**TOWER 2, LEVEL 23  
DARLING PARK, 201 SUSSEX ST  
SYDNEY NSW 2000**

## **SSD 16\_7683: NEW RESTAURANT AND MICRO-BREWERY, OVERSEAS PASSENGER TERMINAL (TENANCY 5)**

**HERITAGE OBJECTION: SSD 16\_7683  
PROPOSED BREWERY AND OUTDOOR BAR  
TENANCY 5, OVERSEAS PASSENGER  
TERMINAL, CIRCULAR QUAY**

Proposal

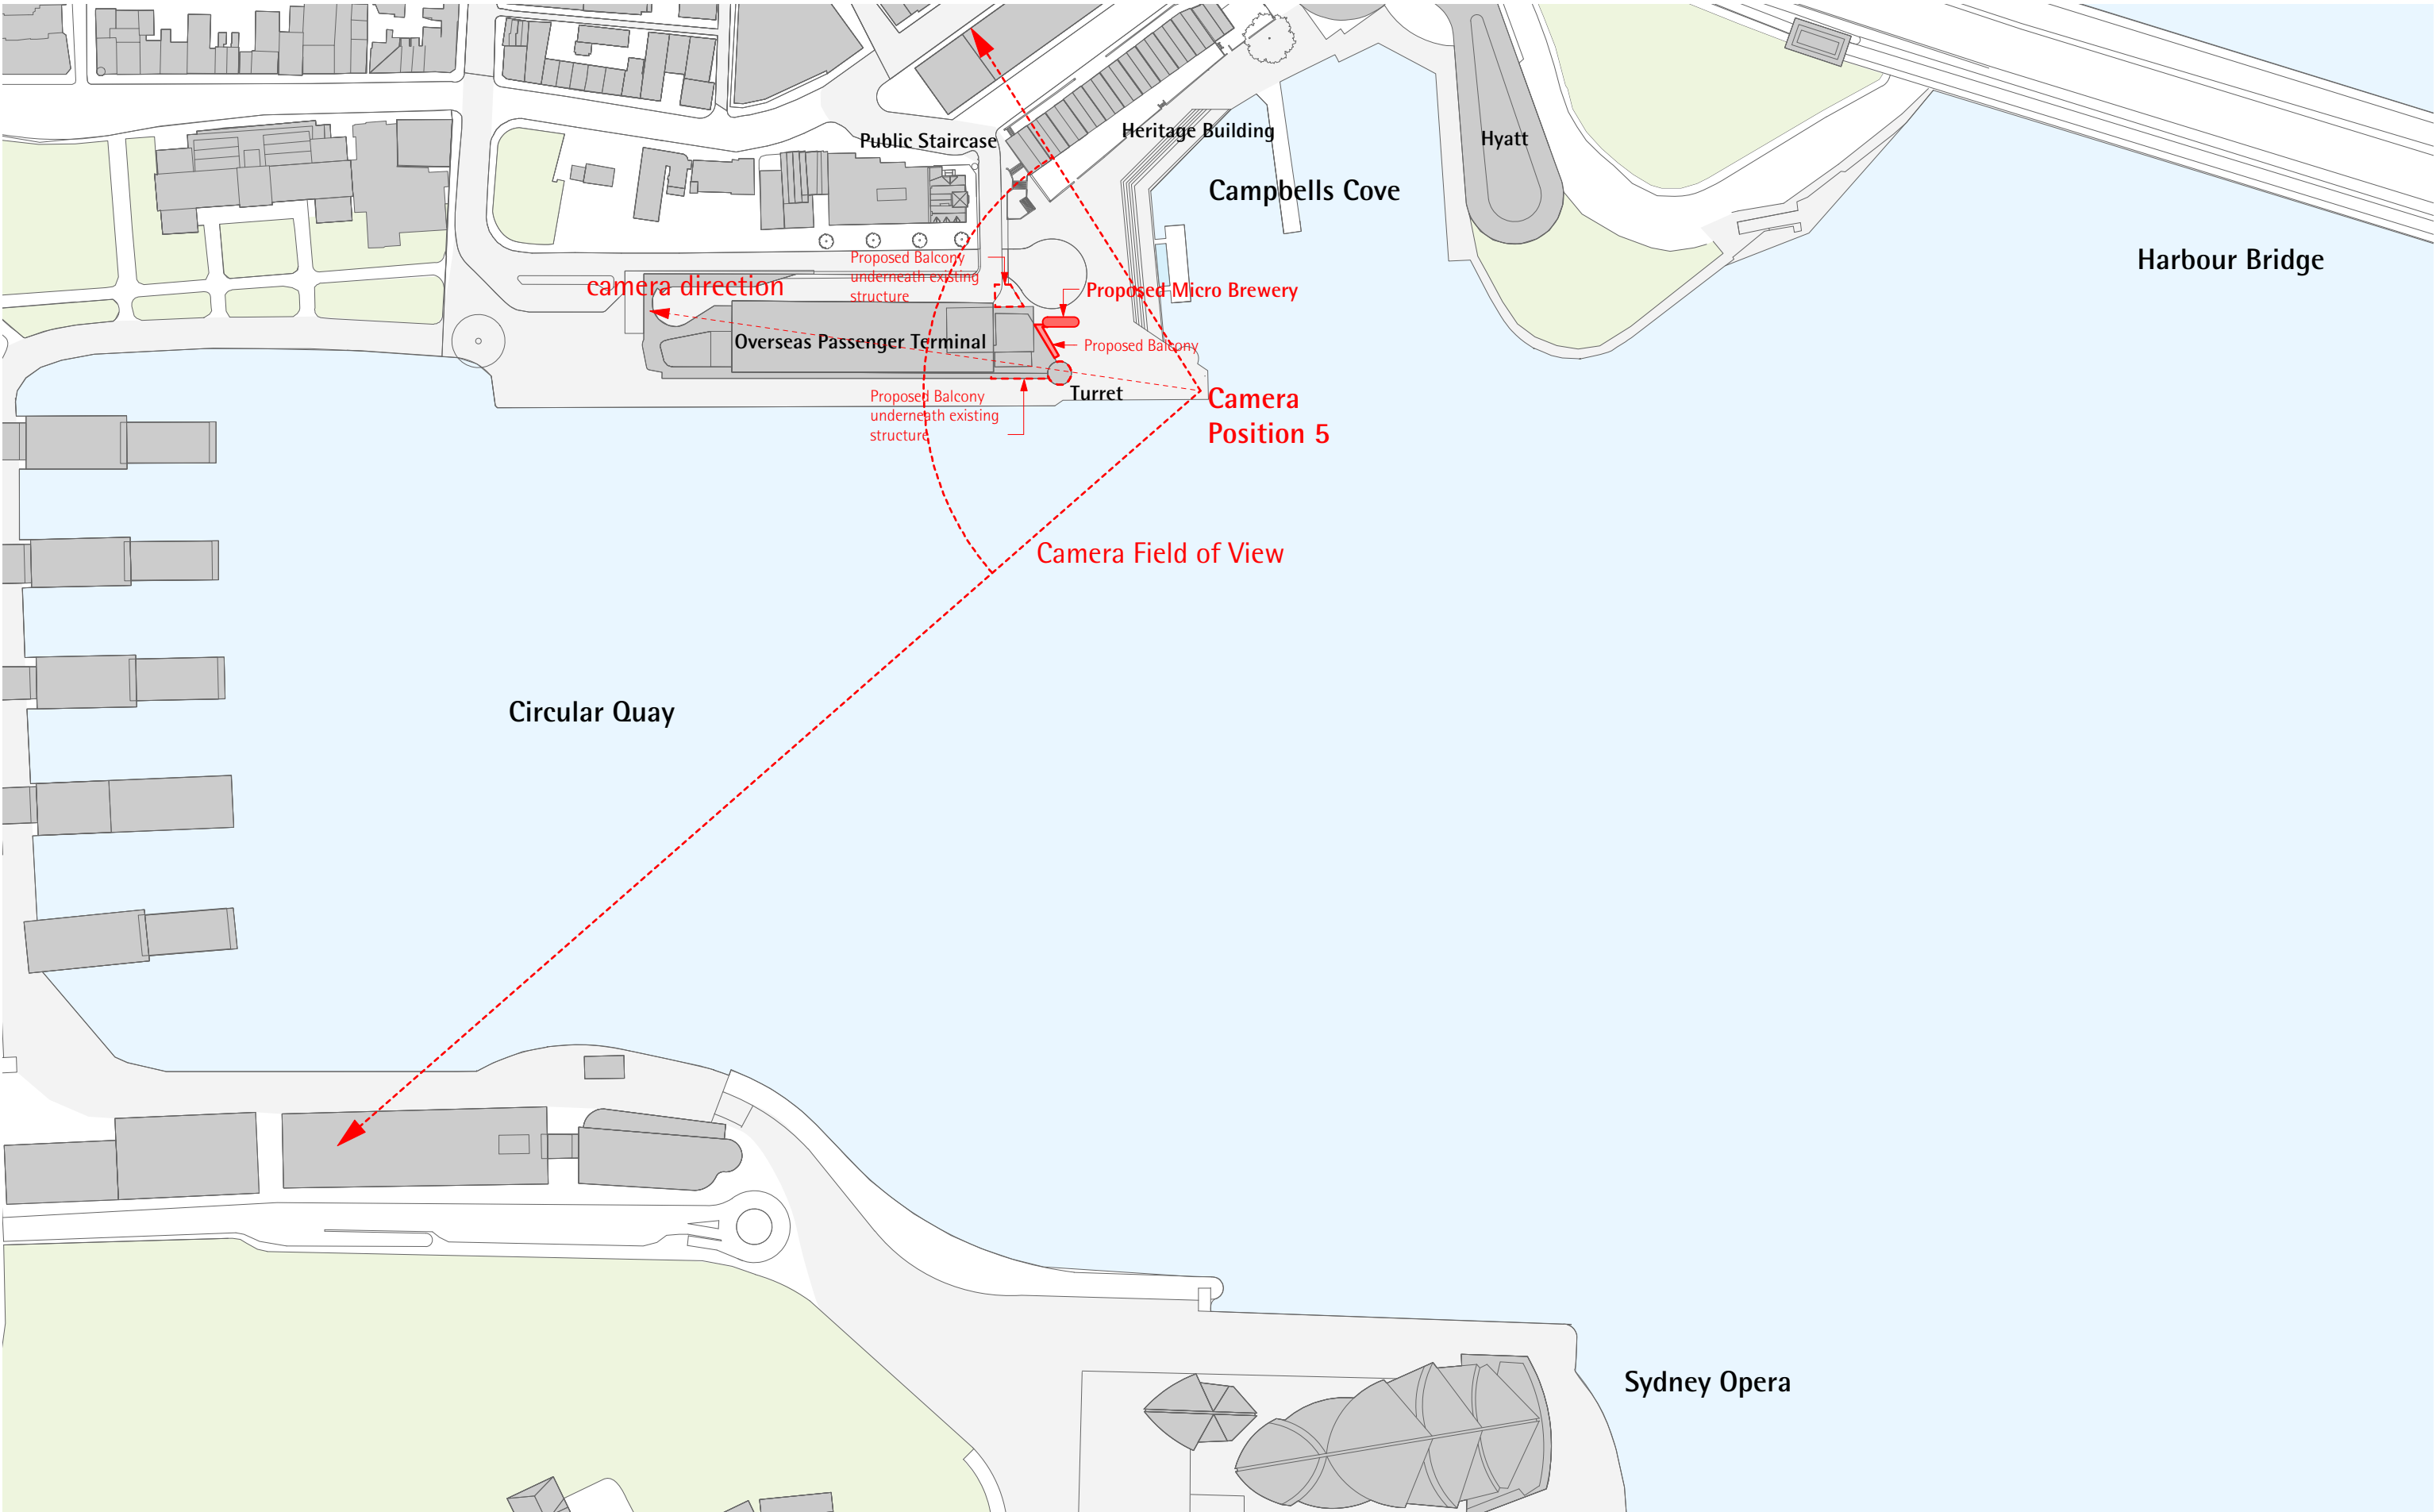
The visual impact analysis undertaken by the applicant is grossly inadequate. The five photomontages produced do not accurately show the proposed development in its entirety. The applicant has made the conscious decision to exclude elements such as the external tables, chairs, balustrades, landscaping and shade structures to reduce the amount of visual clutter.

Further, the five photomontages do not provide an accurate representation of the current and proposed views to and from the Sydney Opera House, Sydney Harbour, Campbell's Cove, and Campbell's Stores. The Department should request that a visual impact assessment be undertaken in accordance with the Land and Environment Court requirements so that the full extent of view loss can be considered.

The Environmental Impact Statement acknowledges that *"views of the Sydney Opera House from the eastern end of Campbell's Stores will be partially impacted by the proposed pod structure"*. We question the validity of this statement given the inadequacy of the visual impact assessment prepared. It is our opinion that views of the Sydney Opera House and Sydney Harbour from the eastern end of Campbell's Stores, including the Bay X public stairs, Bay 1 and Bay 2, and the outdoor dining areas will be significantly impacted by the proposed development. Furthermore, views will also be significantly impacted from the Campbell's Cove public promenade.
